**WELWYN HATFIELD BOROUGH COUNCIL  
EXECUTIVE DIRECTOR - PLANNING, PUBLIC PROTECTION AND GOVERNANCE**

**DELEGATED APPLICATION**

**Application No:** 6/2020/3177/EM  
**Location:** 38 Brockswood Lane Welwyn Garden City AL8 7BG  
**Proposal:** Erection of a part single part double storey rear extension  
**Officer:** Mr James Homer

**Recommendation:** Refused

Scale	Date	Drawn by
1:50/10010/2020	DP	DP
Dwg. No.	Rev.	
DP 1069/01

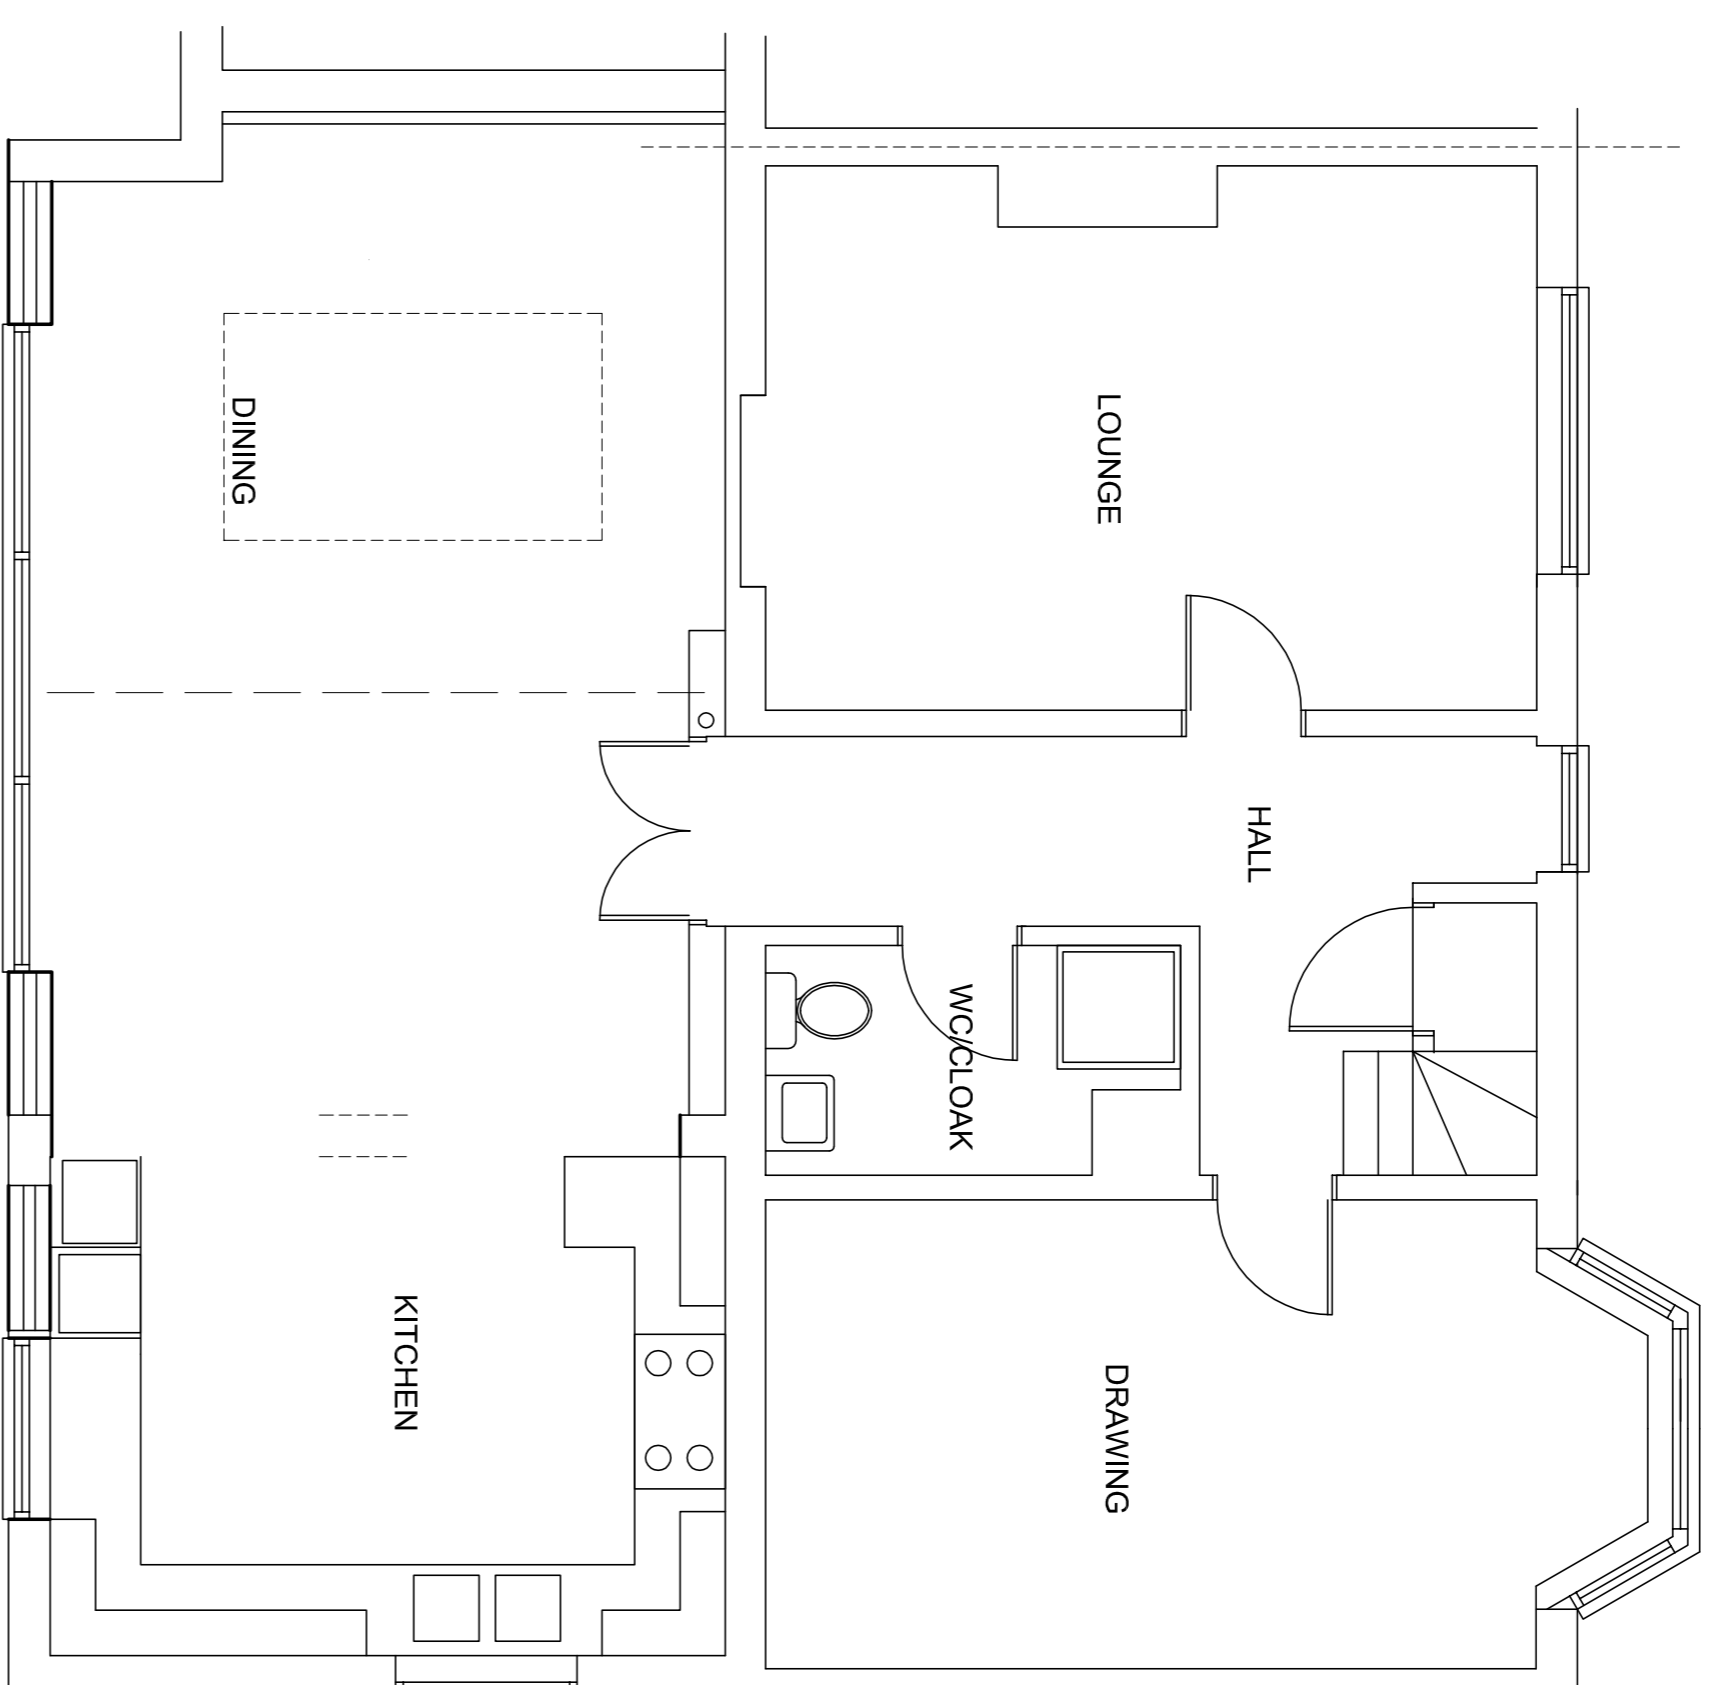
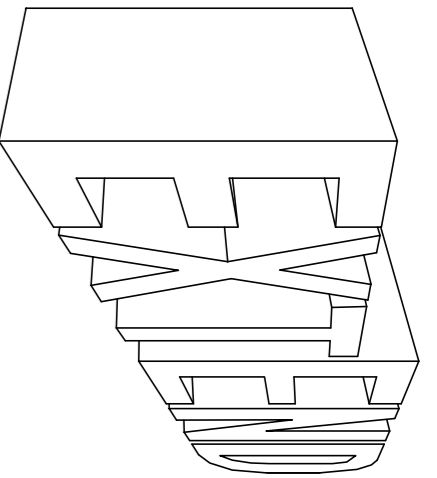
<b>Impact on neighbours</b>	The existing conservatory is upon the boundary with no.36. Although the proposed extension would be at the same depth as the conservatory, the

additional height and solid structure of the extension is likely to overbearing. The concern raised by no.36 regarding the shared wall is outside of EM consideration, however, the applicant would only be able to undertake work within the boundary of their property. Any work to tie in the extension on the neighbour's side would require their consent.
<b>Landscaping issues (incl. hardstandings)</b>	None.
<b>Any other considerations</b>	None.
<b>Conclusion</b>	
The proposed extension is considered too deep, and will result in an addition that would not be proportionate or adequately subordinate to the original house. This would be exacerbate as the roof has not been stepped down to appear subservient to the main building. In addition the proposed extension would introduce an overbearing addition upon the shared neighbour boundary with no.36. Accordingly, the application fails to comply with Policy EM1 of the Estate Management Scheme.

1. The proposed extension is considered too deep, and will result in an addition that would not be proportionate or adequately subordinate to the original house. This would be exacerbate as the roof has not been stepped down to appear subservient to the main building. In addition the proposed extension would introduce an overbearing addition upon the shared neighbour boundary with no.36. Accordingly, the application fails to comply with Policy EM1 of the Estate Management Scheme.
